**CITY OF ALBUQUERQUE
PLANNING DEPARTMENT
June 4, 2014
DRB Comments**

PROJECT # 1004976

**RE: Black Arroyo Dam - Golf Course Road Vacation/ Subdivision
Design Variance from minimum DPM standards**

EXISTING CROSS-ACCESS AND UTILITY EASEMENT RECORDED PLAT DOC# 2007102550

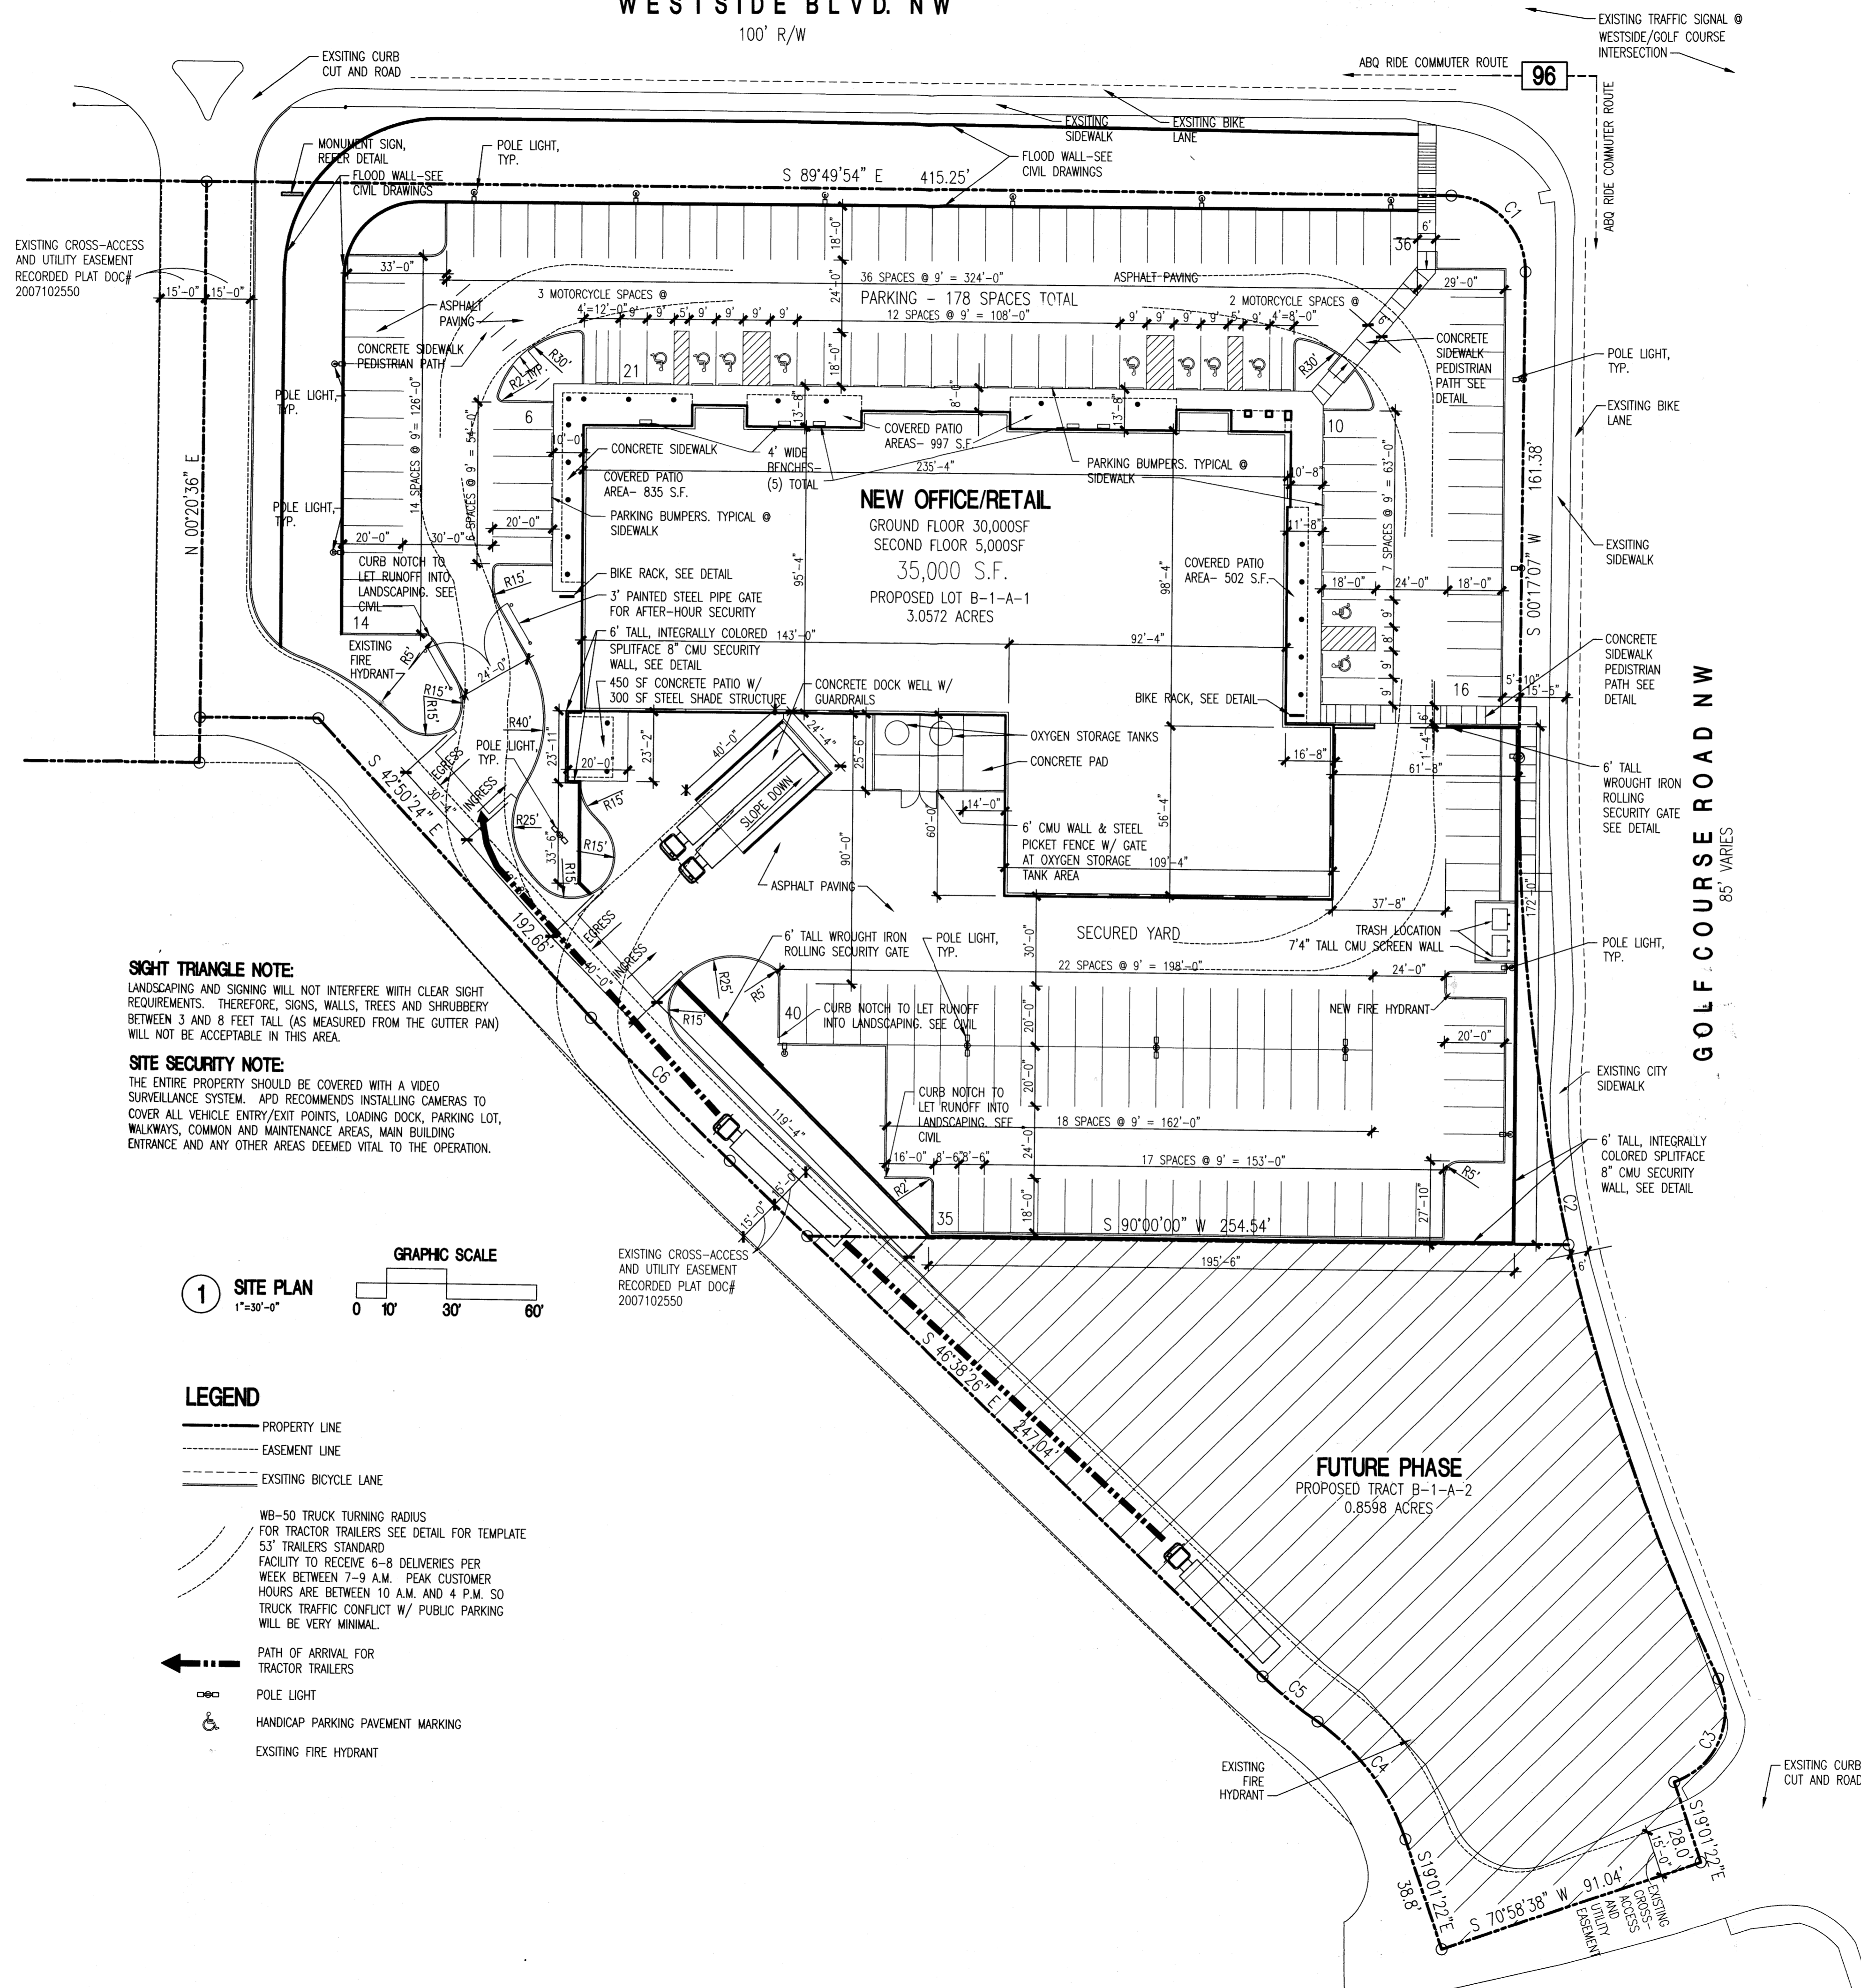
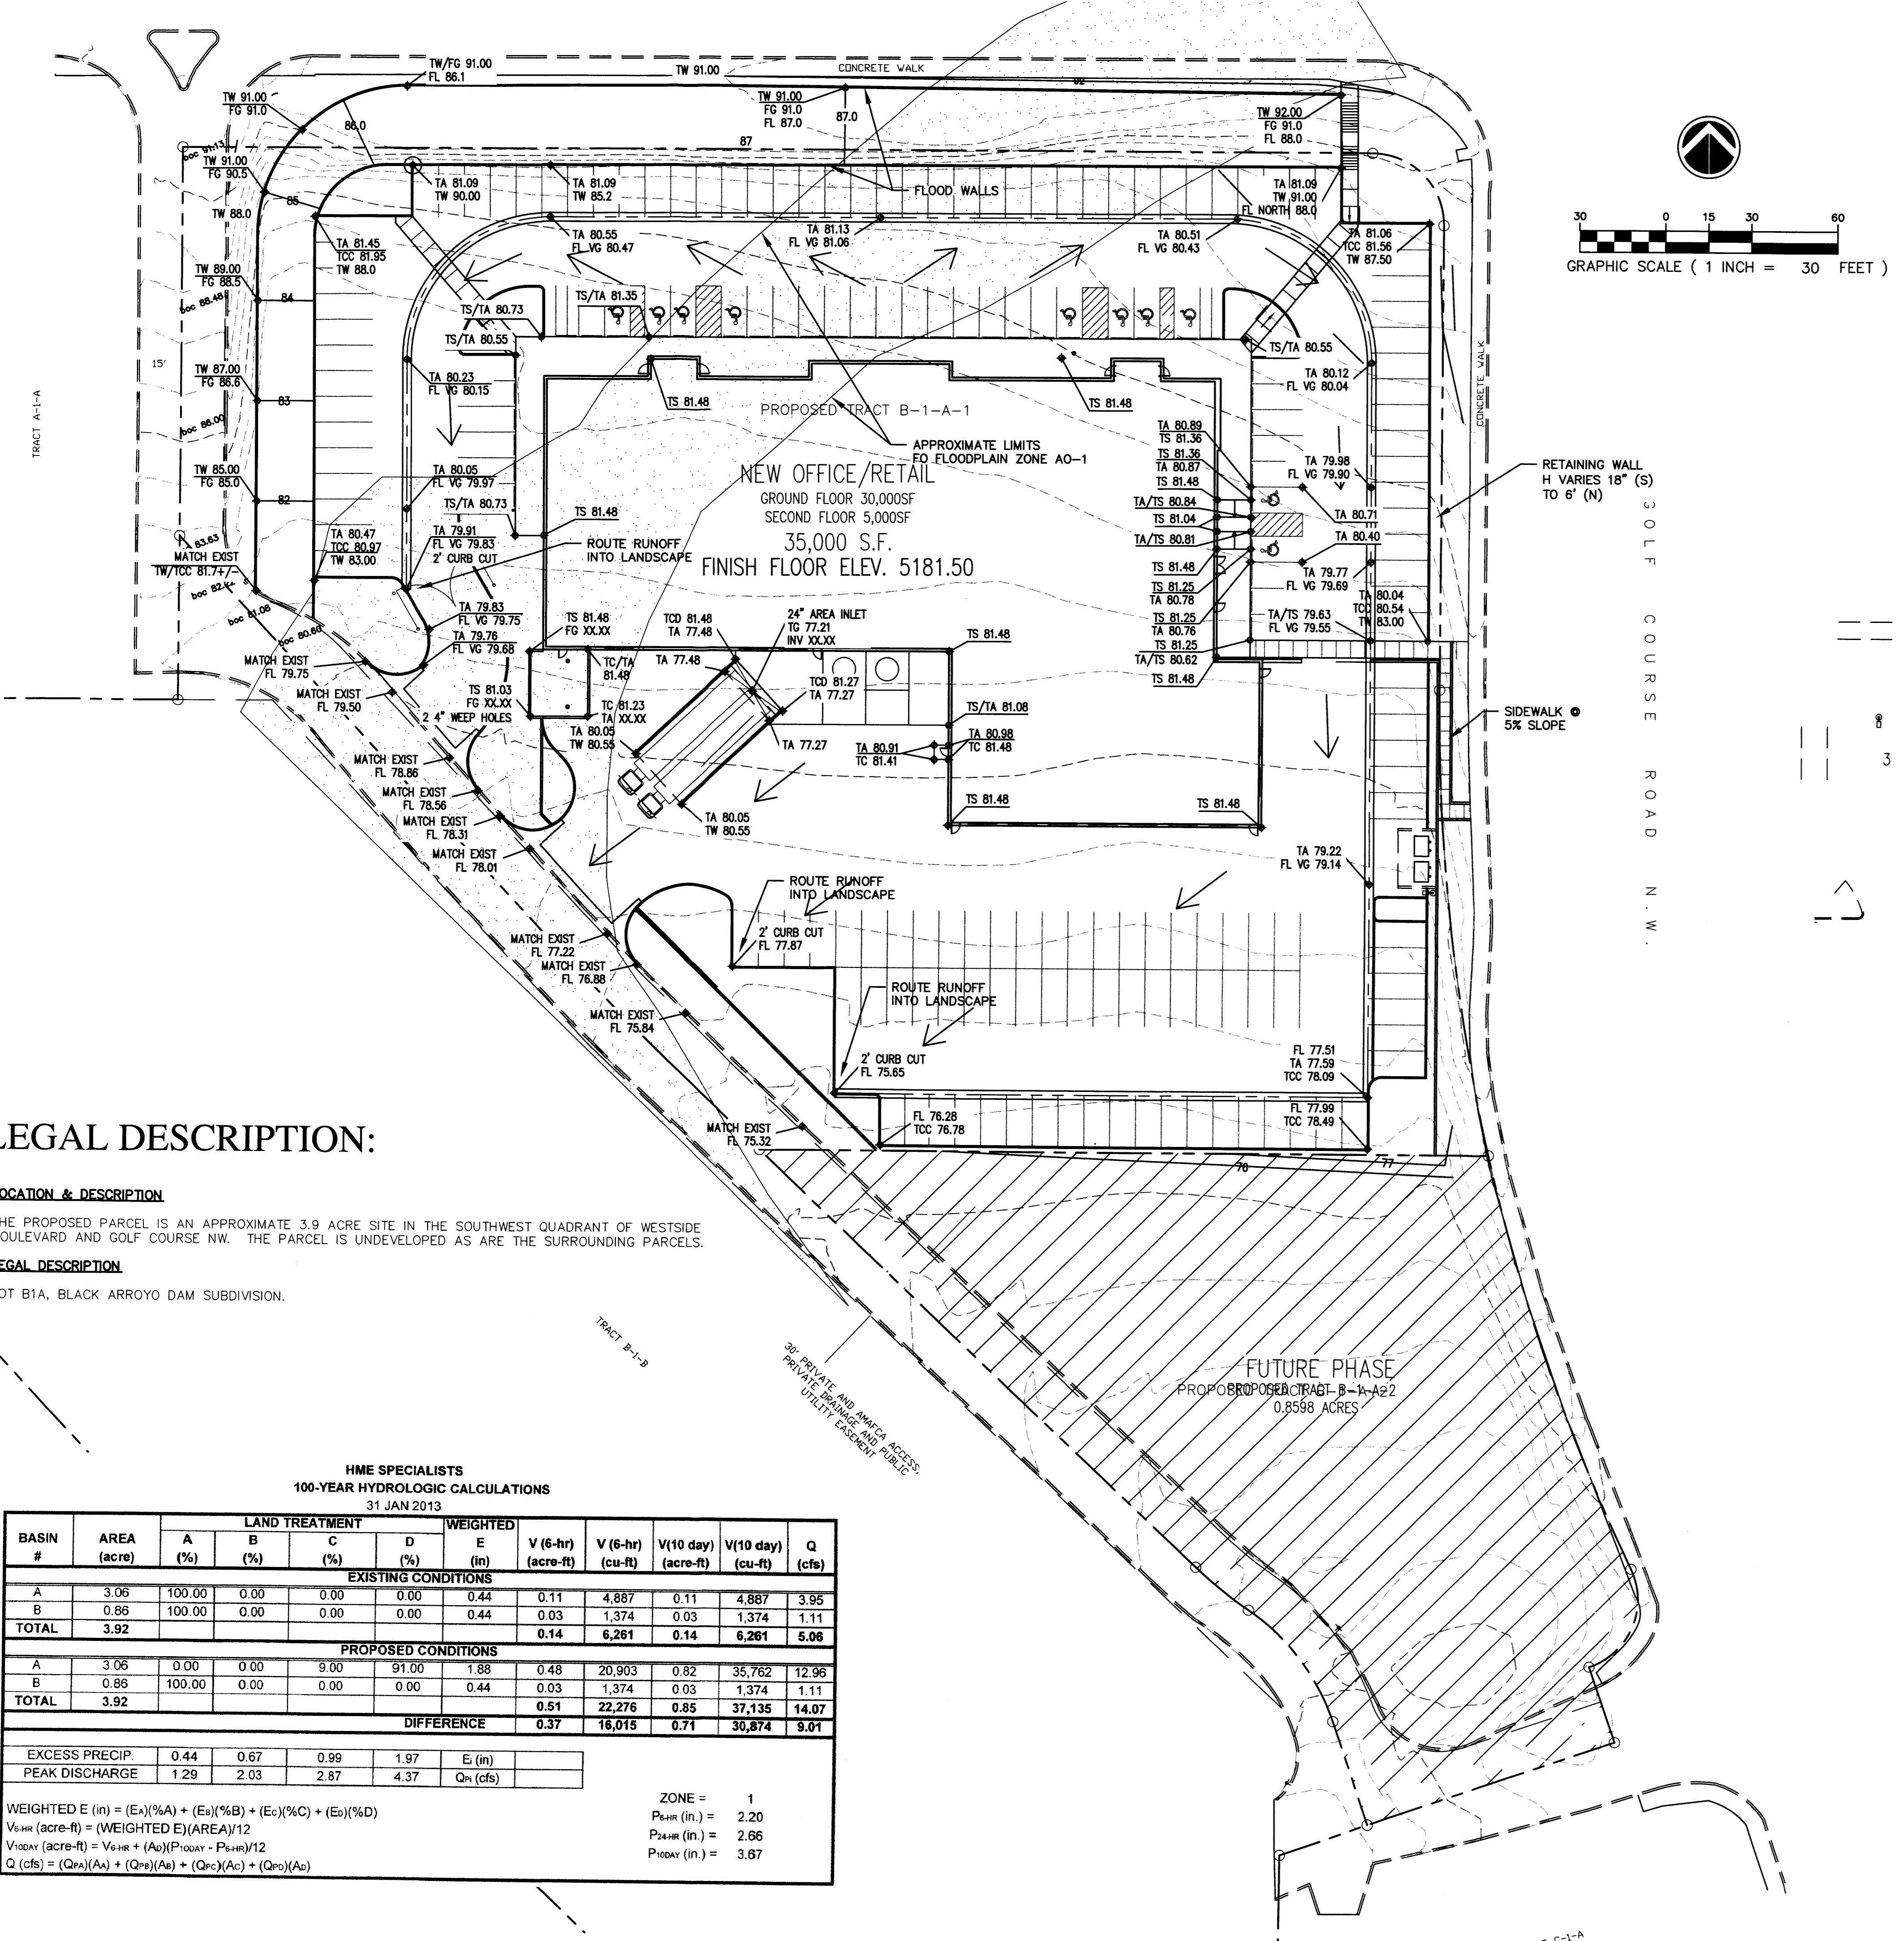
The wall detail facing front is provided, though *the portion of the wall below grade is not shown*. Wheel stops are shown along the interior west and interior north sides of the wall. The *wall cross-section, however, was not provided* so I'm still not sure what the north and west sides of the site would look like.

The wall height is now indicated as 4.75 feet (see Sheet 2), so these design standards would apply to the portion of the wall that is visible from the public ROW (if any). A revised wall detail (facing front) is needed to demonstrate compliance with (B)(2)(a-c) and/or a note to explain that the wall will not face the public ROW. The cross-sections (see Sheet C0-1) show that the wall would be visible from the parking area and would not rise above the ground as viewed from Westside Blvd.
